Markup Summary

REZONE MAP: RR-0.5 RESIDENTIAL TO I-3 HEAVY INDUSTRIAL ZONE

PROPERTY DESCRIPTION: 1755 E. Las Vegas Street

REZONE MAP: RR-0.5 RESIDENTIAL
TO I-3 HEAVY INDUSTRIAL ZONE

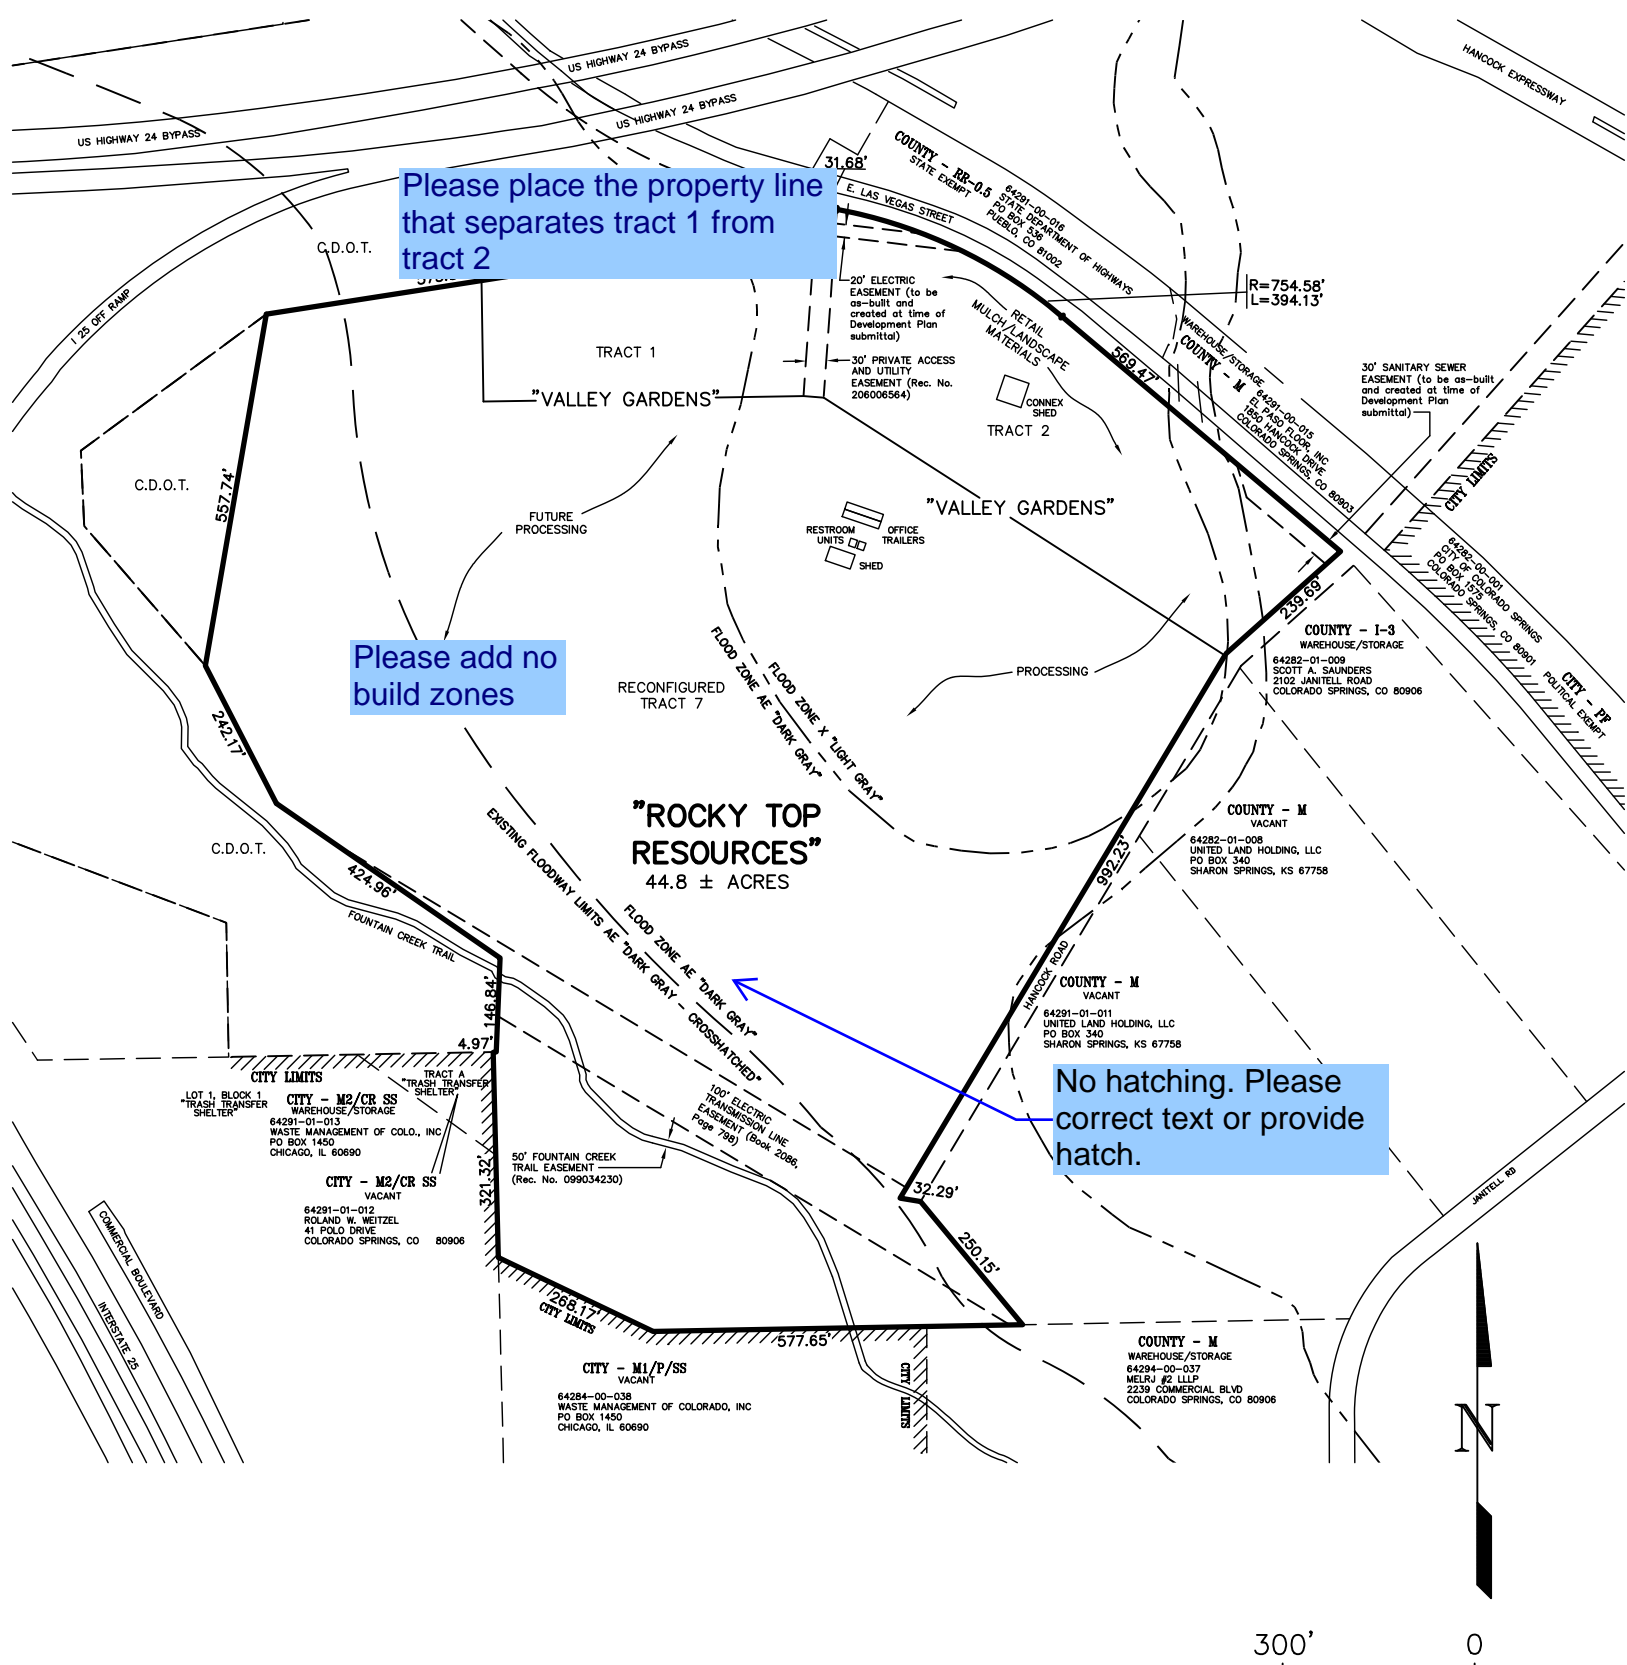
Legal Description is missing information from number 3 on the Title Commitment for the Road that was vacated per resolution 206179579. Legal needs to match Title Commitment Legal

CORRECTED - DVH
